**Dogger Bank South Offshore
Wind Farms**

**The Applicants' Fish and Shellfish Response to the
MMO**

Document Date: April 2025

Document Reference: 14.13

Figure 2-1: The location of International Herring Larval Survey Sampling Stations and underlying EMODnet 1:250k Seabed Sediment Type. Station numbers (ST) and Kilometre Points (KP) are presented for reference

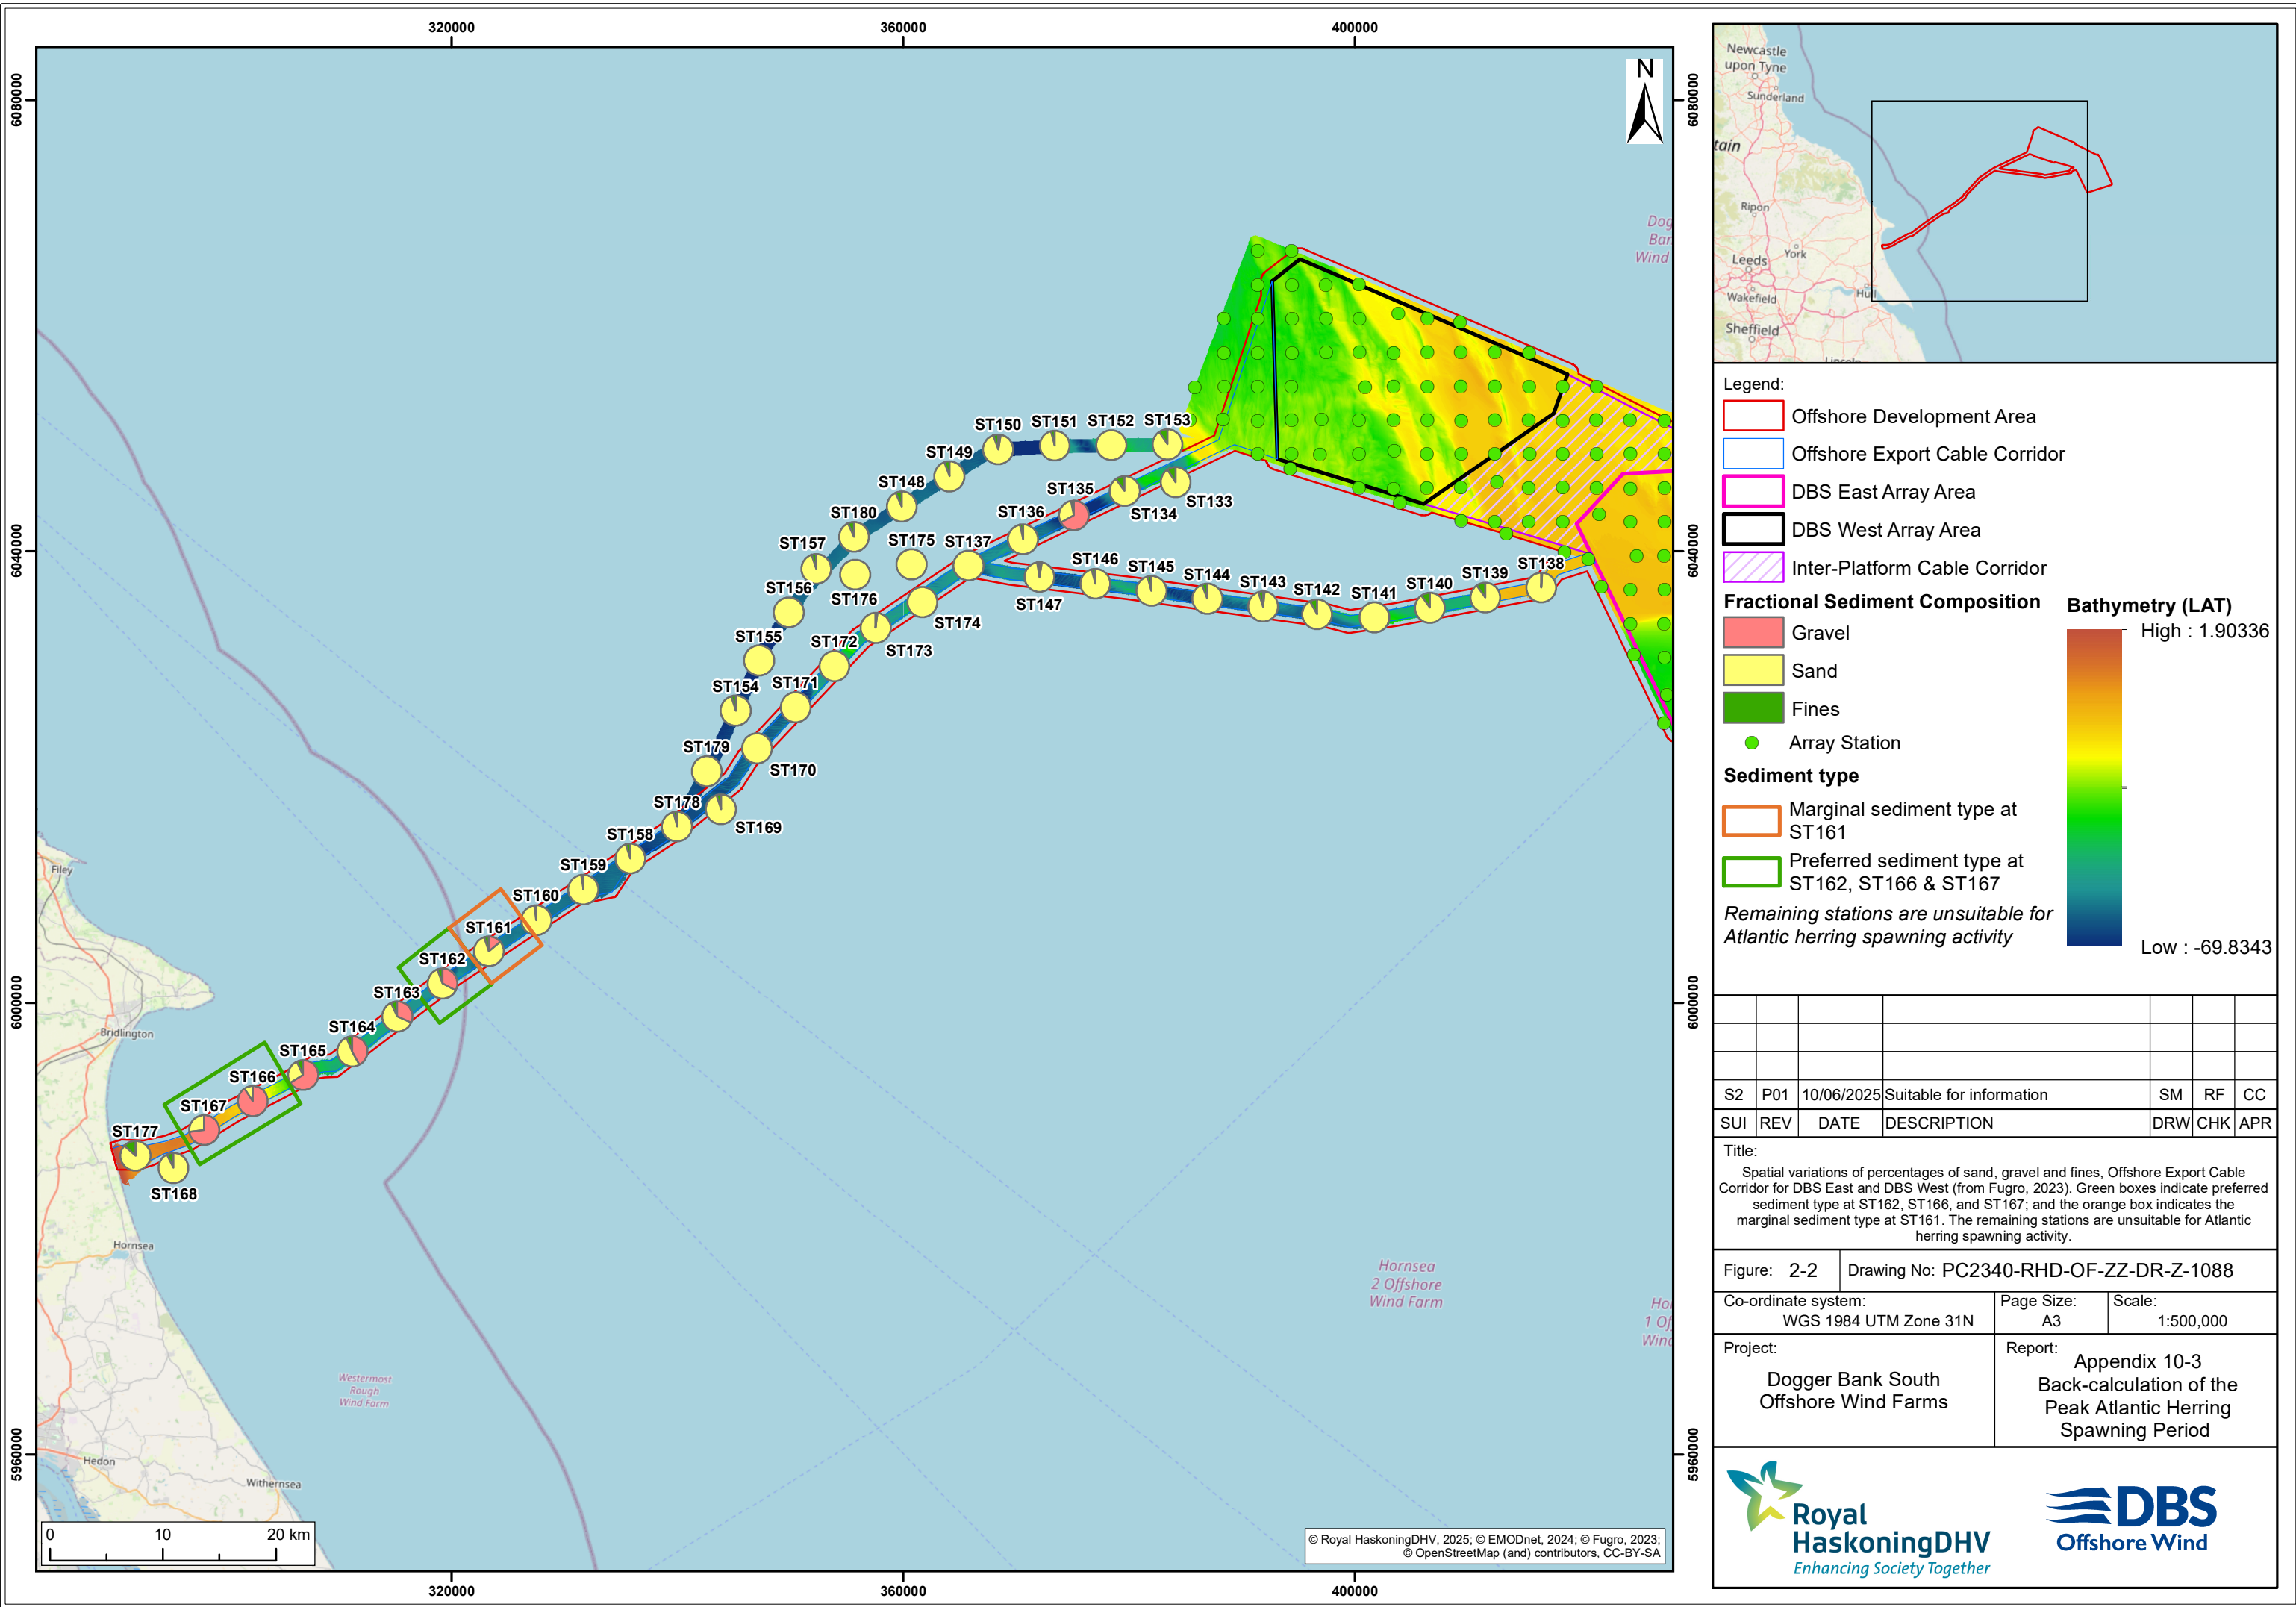
10. High abundances of larvae (200-600 larvae per m²) have been recorded between KP50 - KP60, however this location is ground-truthed (i.e. interpolated data confirmed to be true or false via direct sediment sampling) as being unsuitable sediment type for spawning. In this location, it is likely that larvae have drifted from potential habitat outside of the Offshore Export Cable Corridor (as described in the **Heat Mapping Report: Atlantic Herring and Sandeel** [AS-105]).

11. The **Heat Mapping Report: Atlantic Herring and Sandeel** [AS-105] clearly shows that the Projects' Offshore Export Cable Corridor has a lower larval abundance compared to areas to the north or south, with the exception of one IHLS station that recorded >600 larvae per m² (942 larvae per m²) between KP20-KP30 in 2011 only.
